Arun District Council
Arun Civic Centre
Maltravers Road
Littlehampton
West Sussex BN17 5LF
Planning & Building Control General Enquiries
Tel: (01903) 737756 Fax: (01903) 730442
Dx: 57406 Littlehampton
Minicom: 01903 732765
e-mail: planning@arun.gov.uk
website: www.arun.gov.uk/planning

Application No: FP/31/22/PL
Site Address: 107 Felpham Way Felpham PO22 8QB
Description of works: Construction of a pair of semi-detached dwellings with electric mobility scooter/cycle & refuse storage facilities. This site is in CIL Zone 4 and is CIL Liable as new dwellings.

Thank you for your internet representation made on 9th March 2022 which has been recorded as an objection with the comments as follows:

OWPC45027

Project		Land to rear 107 Felpham, Bognor Regis	
Drawing		Sketch Site Plan	
Date	august 2021	Drawn by	
Scales	1:100 @ A1	Suitability	sketch
Doc No	DLS-031-SK-11-B	Revision	C

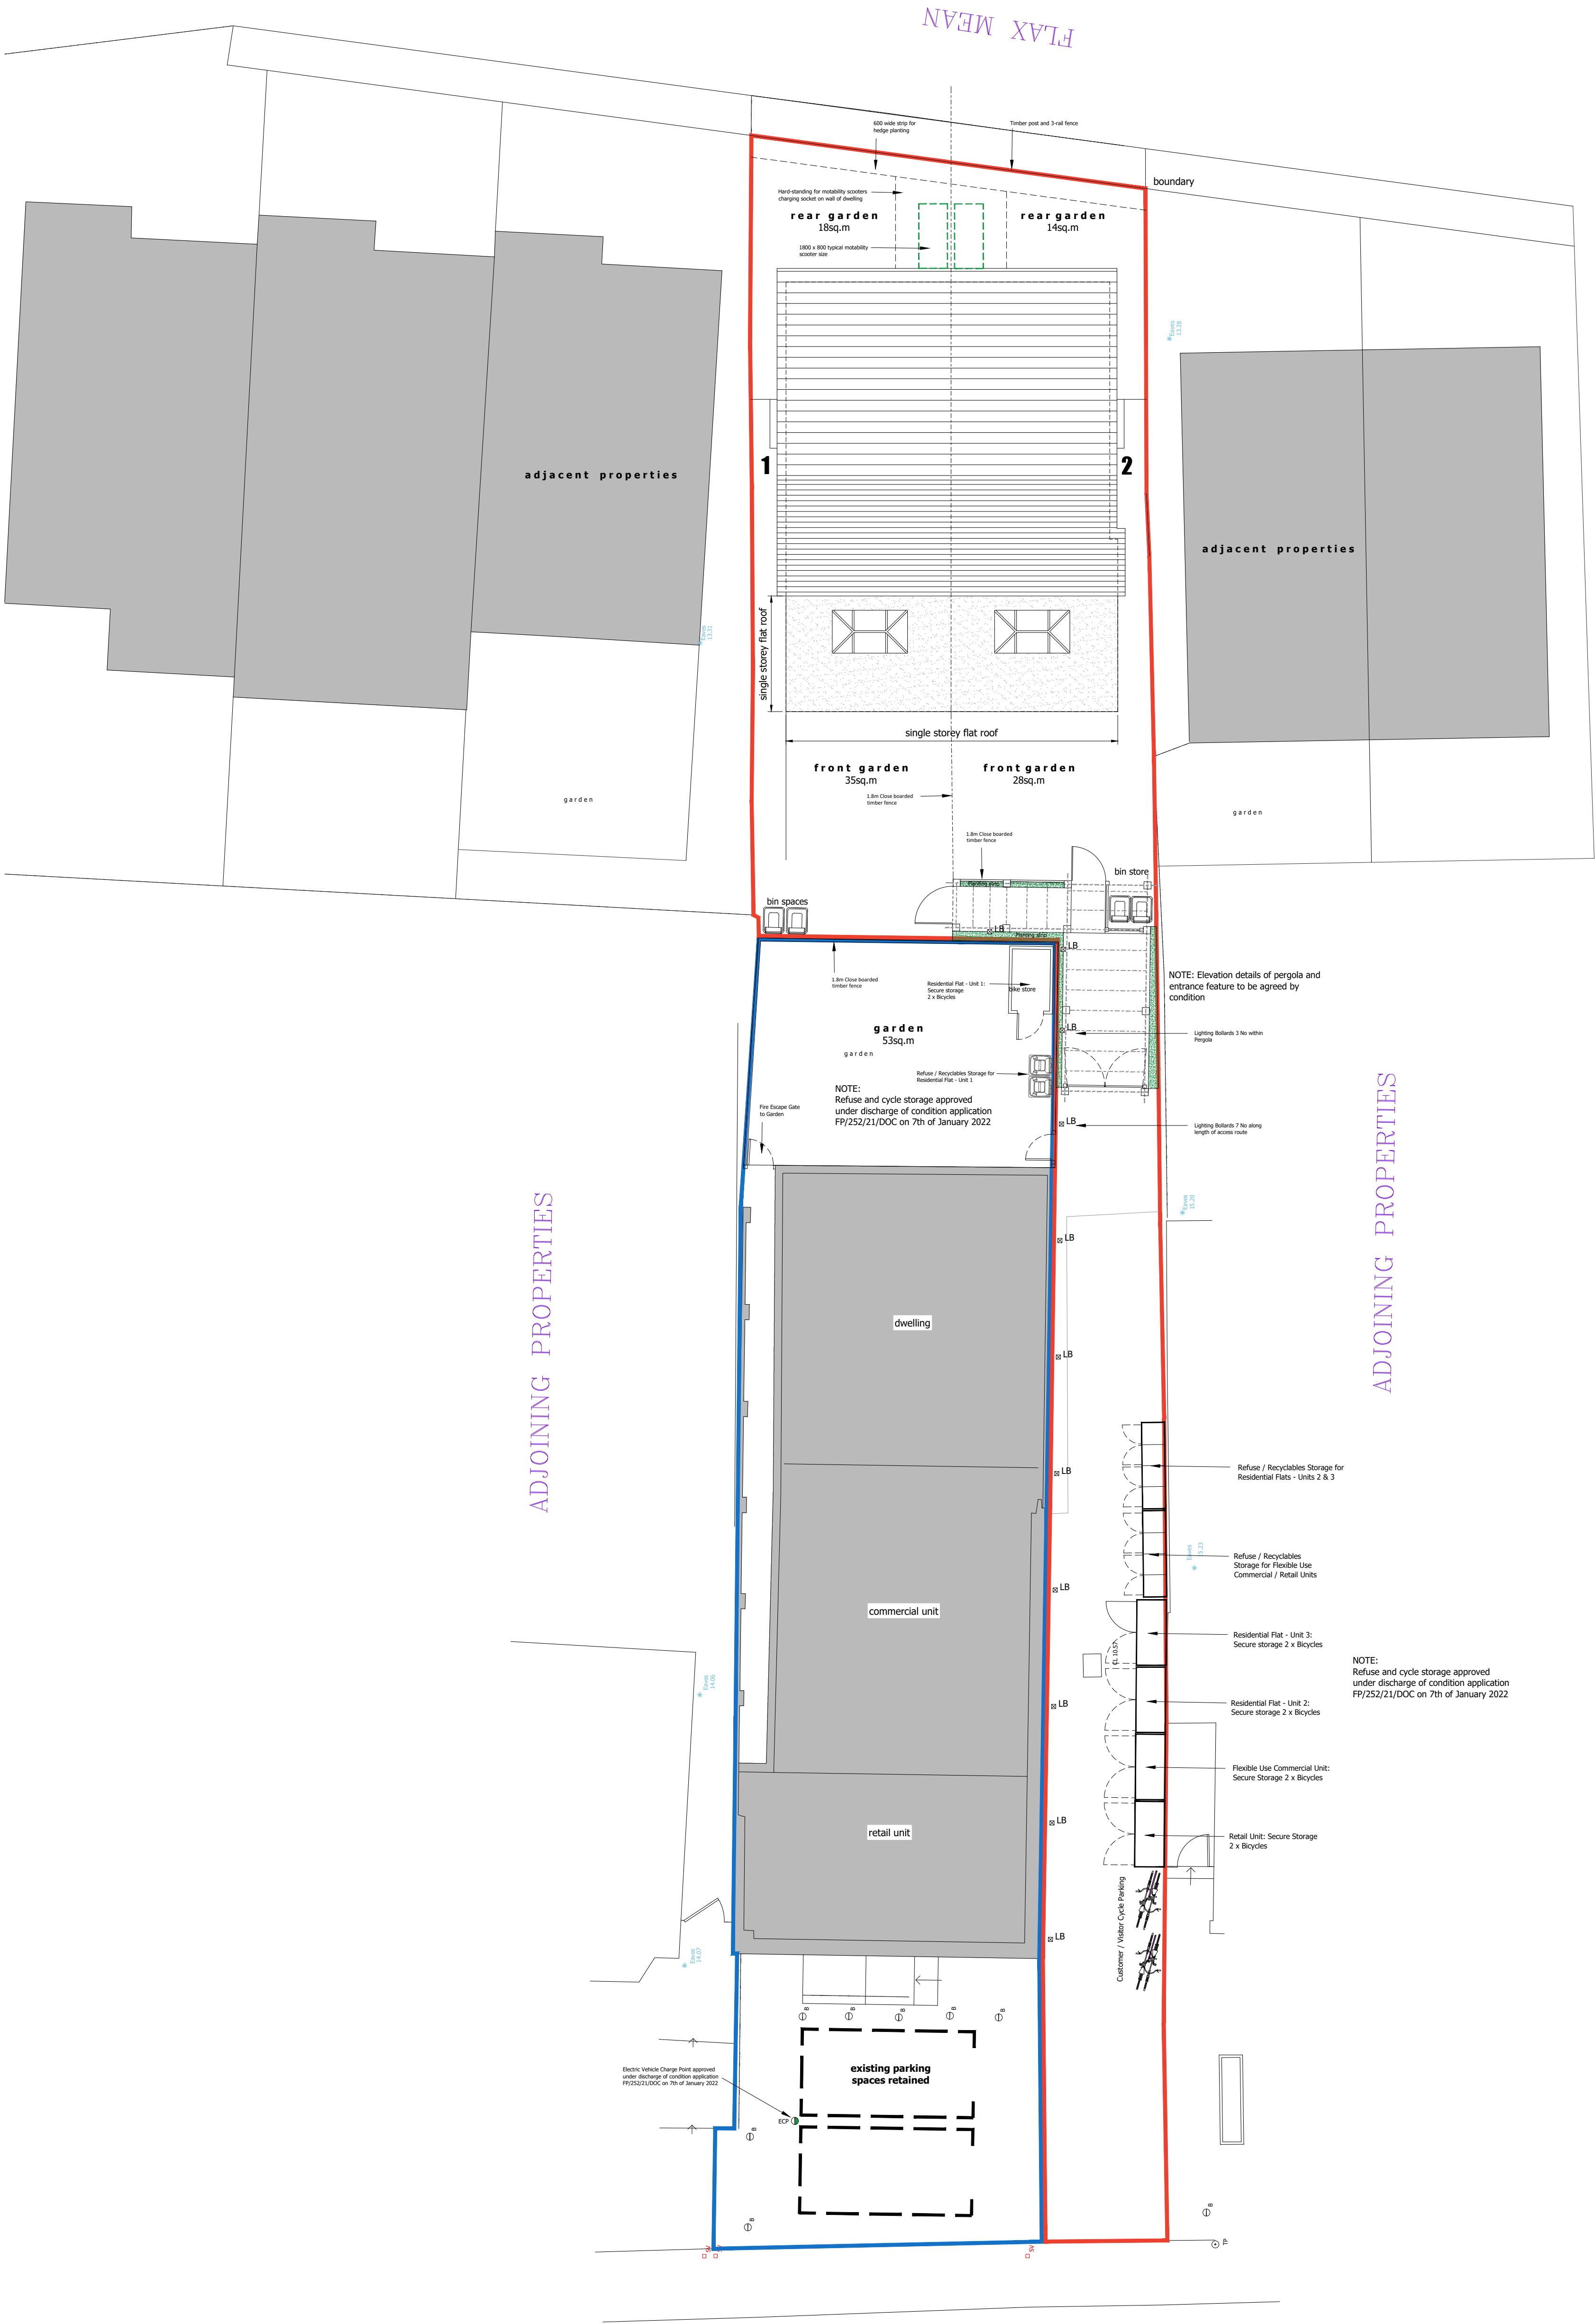
1. Does not comply with ADC supplementary planning guidance October 2020 on parking (1 x bedroom dwelling requires 2 spaces therefore 4 required. Parking stated to be on street.

6. States will comply with minimum space standard. RIBA state that a one-bedroom property with a double bed must be 50 m² - single bed space 37 m². Drawing implies a single bed bedroom facility - units measure

47.2 m2 and 46.1m2. Nothing to prohibit a double sized bed being squeezed in. Overdevelopment.

7. Felpham Parish Council Traffic Survey (November 2021) indicates that daily, Monday to Friday, in excess of 17,000 vehicles travel past the location in excess of 30mph and up to 55mph. The committee has concerns that residents with restricted mobility may require regular care visits and with no off road parking for visitors, given the location of the site, this could potentially be hazardous.

Drawing No.	Rev.
2021-6359-001	B

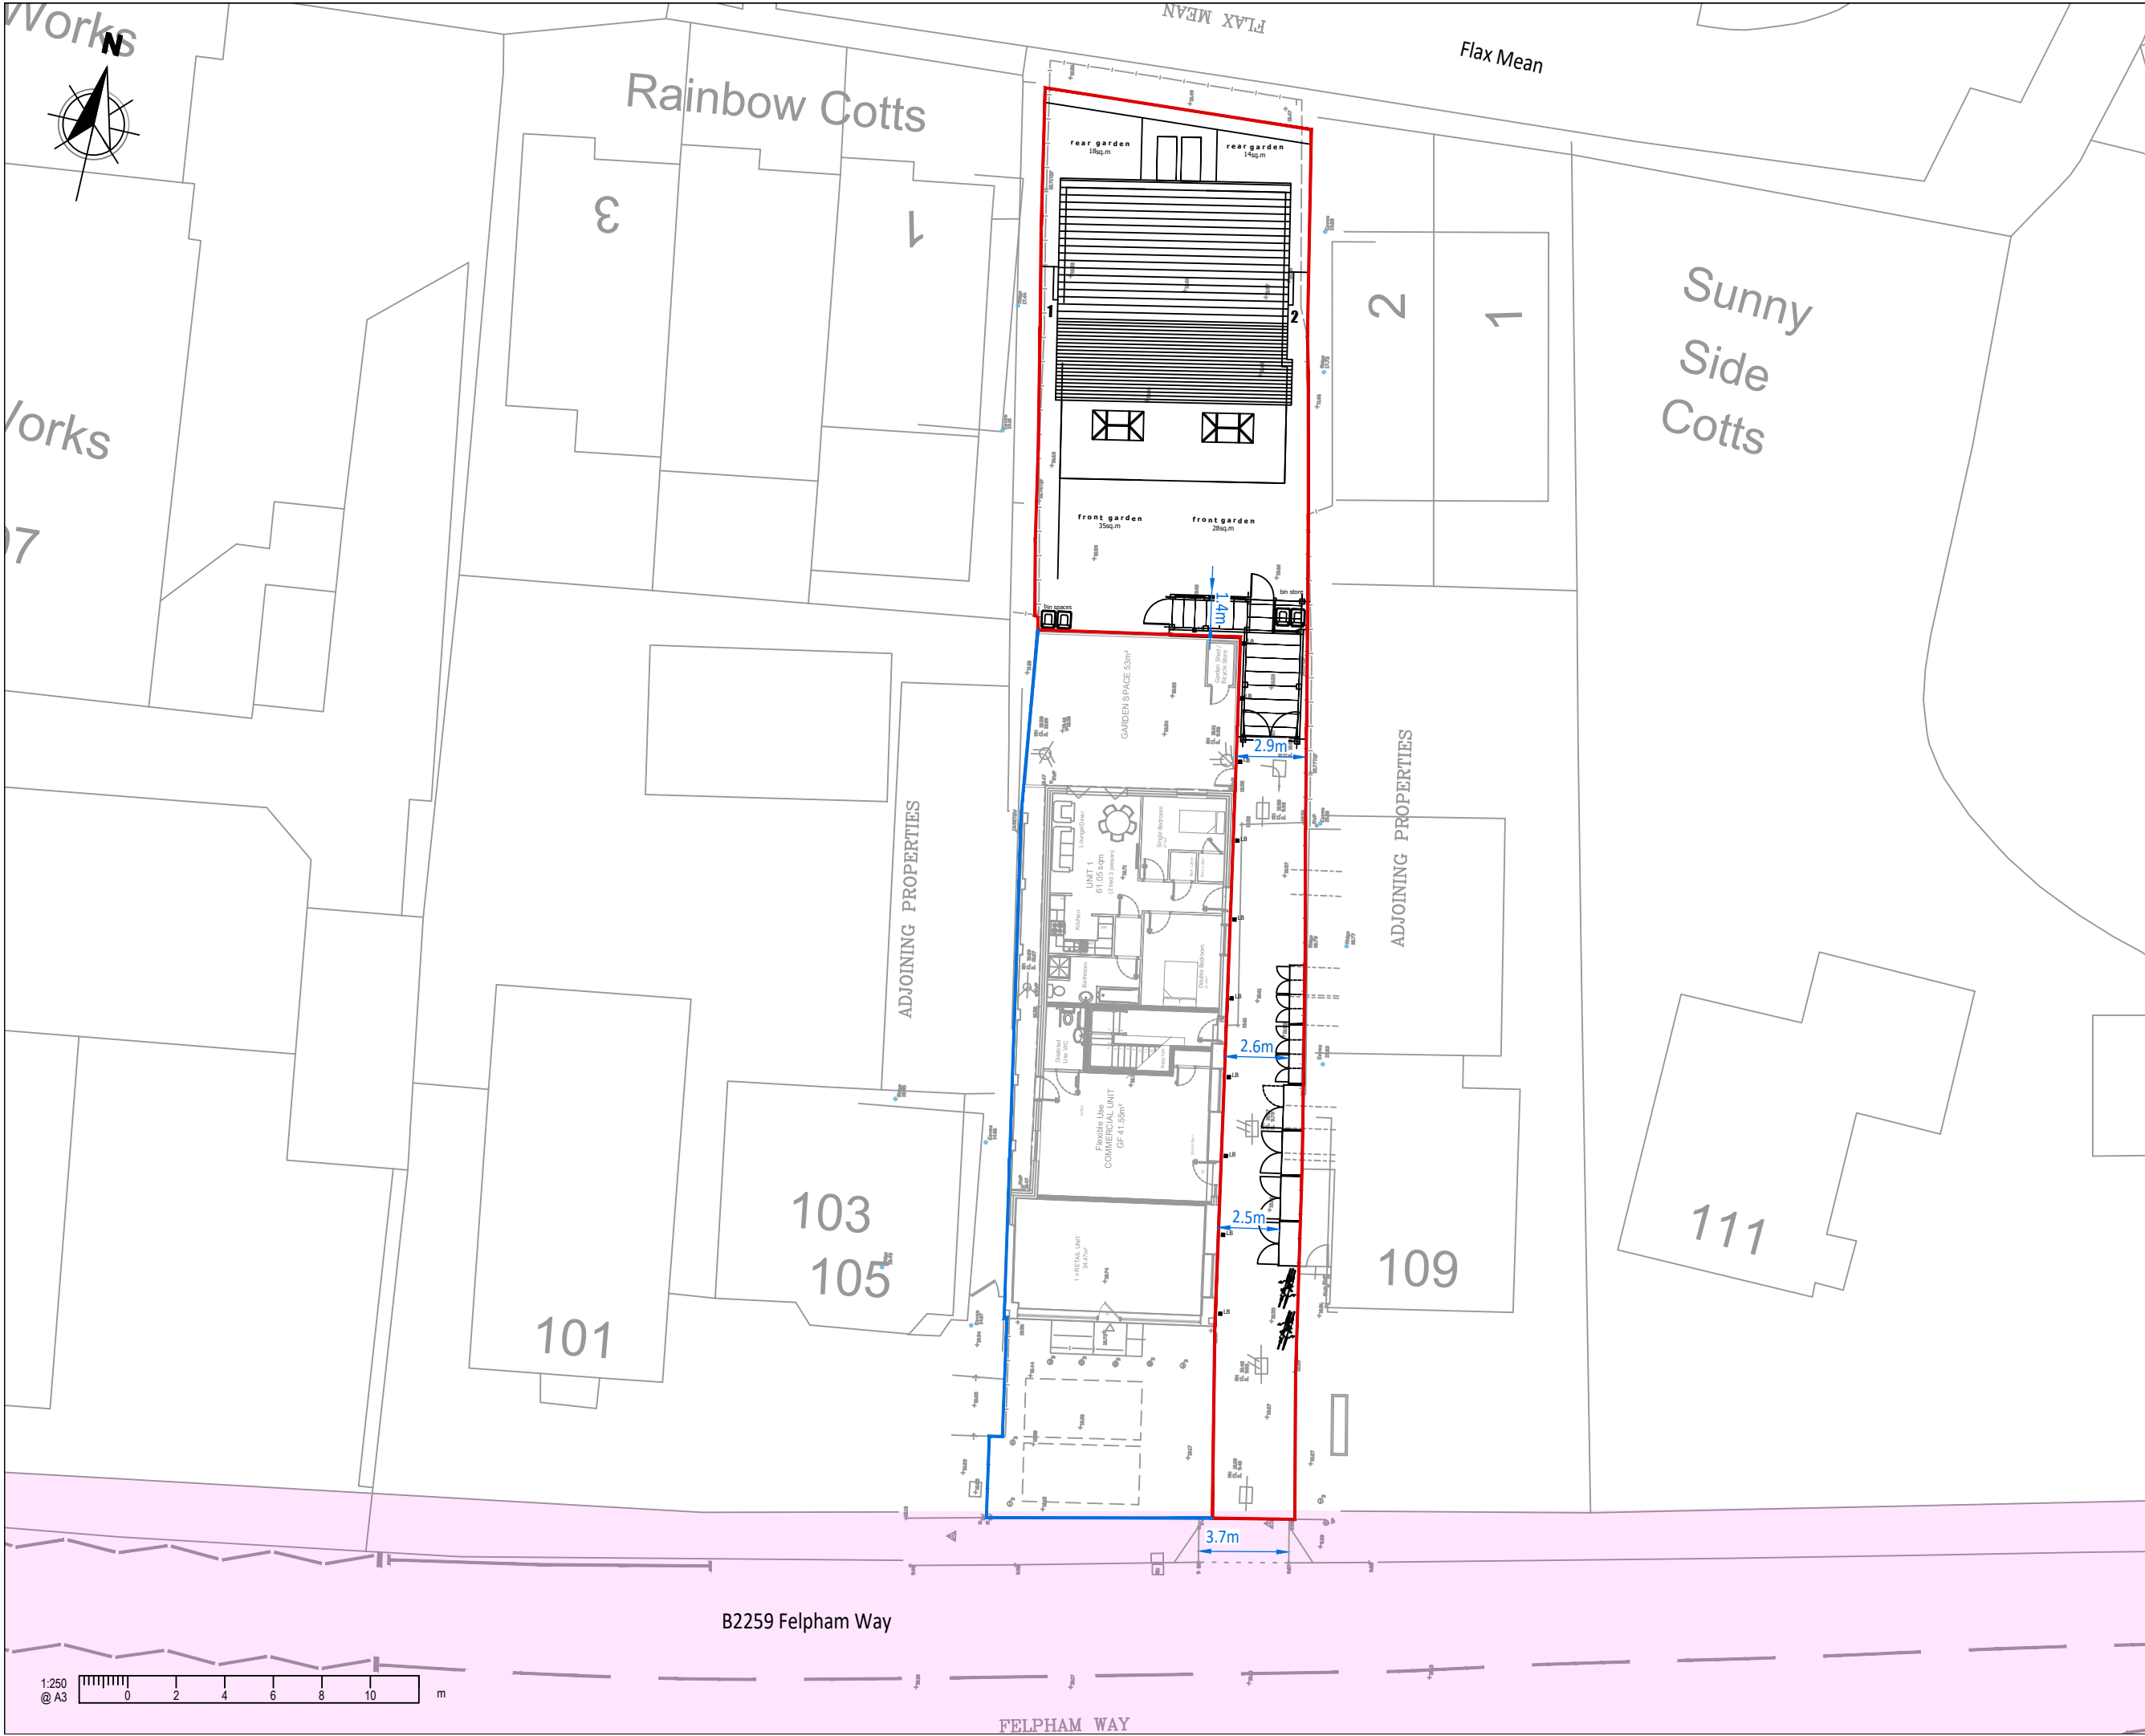
3. FPC disputes the 31 spaces stated as being in Felpham Way. Parking is prohibited on the south side of Felpham Way. Parking is also prohibited west of the applicant's site as there is a roundabout. Thus, the only parking available is on the north side of Felpham Way to the east side of the applicant's site. Using the assessments own measurements, the 31 spaces require 188m without drop kerbs and access points. This would not be achieved prior to the parking controls starting on the north side of Felpham way west of the Southdown's pub nor is it within the 200m walking distance quoted as standard. 12 spaces required as overspill from current development.

4. FPC disputes the 19 spaces stated in Summerley Lane. Parking is only permitted on the west side and with the introduction of speed ramps this number is reduced.

5. The traffic Impact Assessment is flawed with incorrect counting, distances exceeded and incorrect assessment of numbers available in Felpham Way. Firs Avenue, Summerley Lane, Wick Lane, Clovelly Avenue and parts of Felpham Way are all greater than the 200 m distance quoted and thus should be discounted. FPC does NOT agree that the development parking demand can be accommodated safely on the local road network.
